RE: Burger King – 5101 Gibson Blvd SE
Grading and Drainage Plan
Engineer's Stamp Date: 09/26/18
Hydrology File: L18D084

Based upon the information provided in your resubmittal received 09/28/2018, the Grading and Drainage Plan is approved for Building Permit and SO-19 Permit.

RE: Burger King – 5101 Gibson Blvd SE
Grading and Drainage Plan
Engineer's Stamp Date: 09/04/18
Hydrology File: L18D084

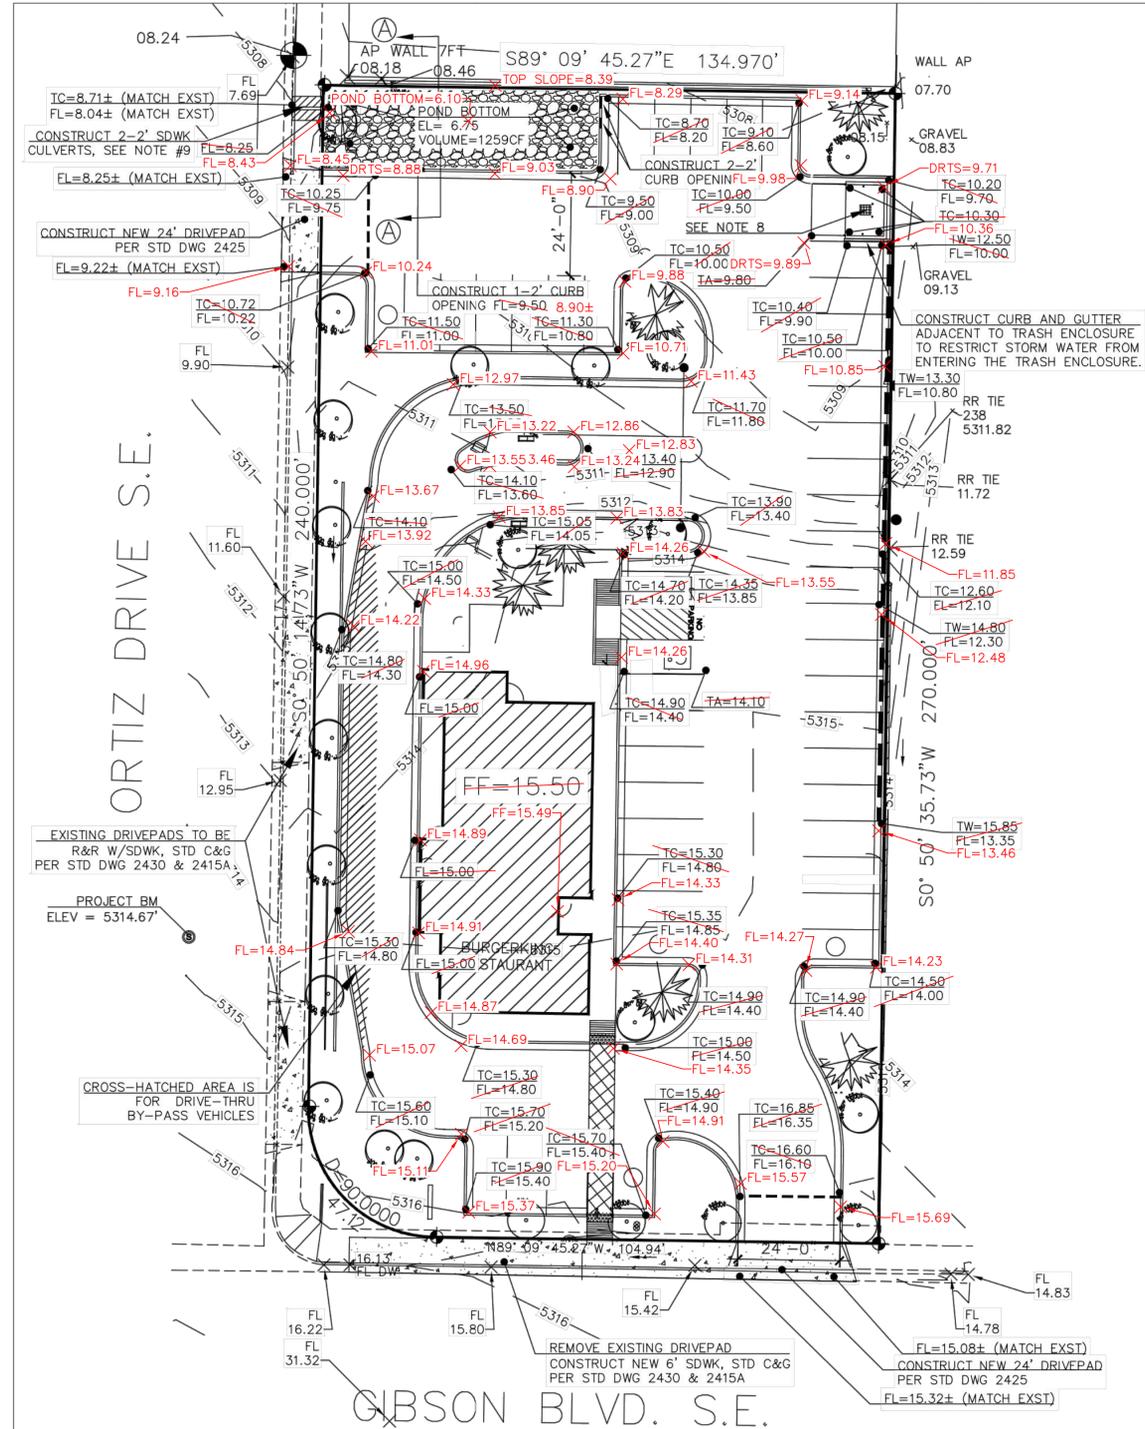
1. Please provide the benchmark information for the survey contour information provided.

2. Please add the effective date of the FIRM Map to General Note #1.

3. The storm water quality volume is calculated based on the 0.44 inch storm. To calculate the required storm water quality volume to be captured, multiply the impervious area (SF) by 0.34 inches for the 90th percentile storm. Please redo the first flush calculations. The required volume should be 9,572 CF.

4. Near the dumpster, please change the inlet reference note to note 8.

5. Please clarify what the hatching in the pavement on the West side of the building is.

6. Please add the top of wall and flow line information to the proposed garden/retaining wall. Also please clarify in the detail on Sheet 2 is the curb going to be right next to the wall or is the wall acting as the curb for the parking lot?

7. Near the dumpster, please redirect the sheet flow around the dumpster so that the runoff will discharge into the first flush pond and not the inlet that is in the dumpster enclosure.

1. Bench mark information has been included.
2. FIRM map information has been added.
3. The storm water quality calculation has been changed.
4. Note for the dumpster has been changed.
5. Pavement hatching note has been added.
6. Top of wall and flowline spot elevations have been added, along with the clarification of the section adjacent to the wall.
7. A curb has been added adjacent to the dumpster enclosure to keep storm water out of the dumpster area.
